Ribble Valley Borough Council
Housing & Development Control

Application no: **3/2020/0015**

Address: **Sherburn Beechthorpe Avenue Waddington BB7 3HT**

Proposal: **New entrance porch, removal of chimney stack, constructions of dormers to rear and side elevations, demolition of existing garage and construction of new detached garage**

Client: Miss A Woodruff			
Project: Proposed Alterations Sherburn Beechthorpe Avenue Waddington			
Dwg title: Proposed Site Plan			
Scale of A4:	Date:	Drawing:	
1:200	06.12.19	PD	
Drawing no:	Rev:		
1150 - 102	-

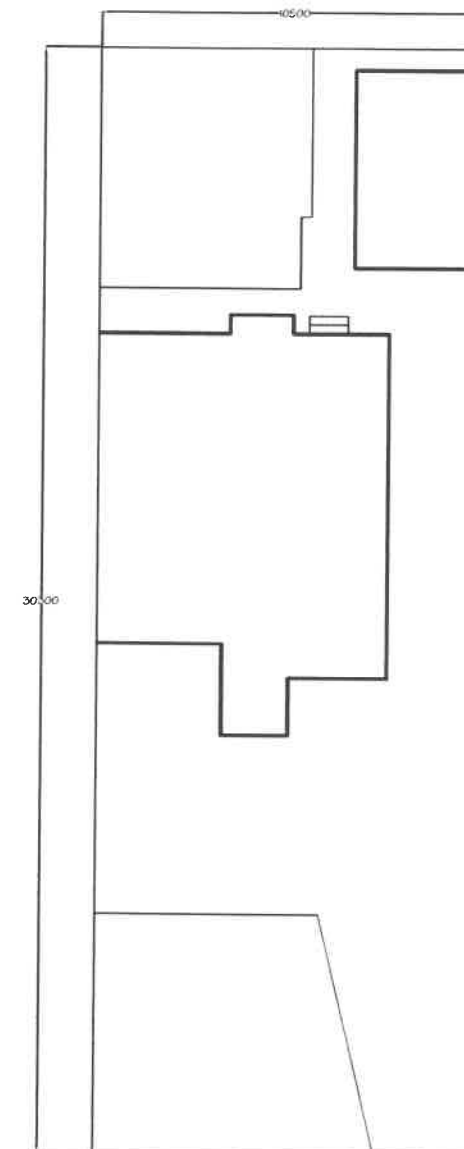
The proposal is for alterations to be made to an existing dwelling along with the demolition and re-construction of a new garage. The parking provision will be retained as a result of the proposal, and overall would not raise any highway concerns.

I would raise no objection to the proposal on highway grounds.
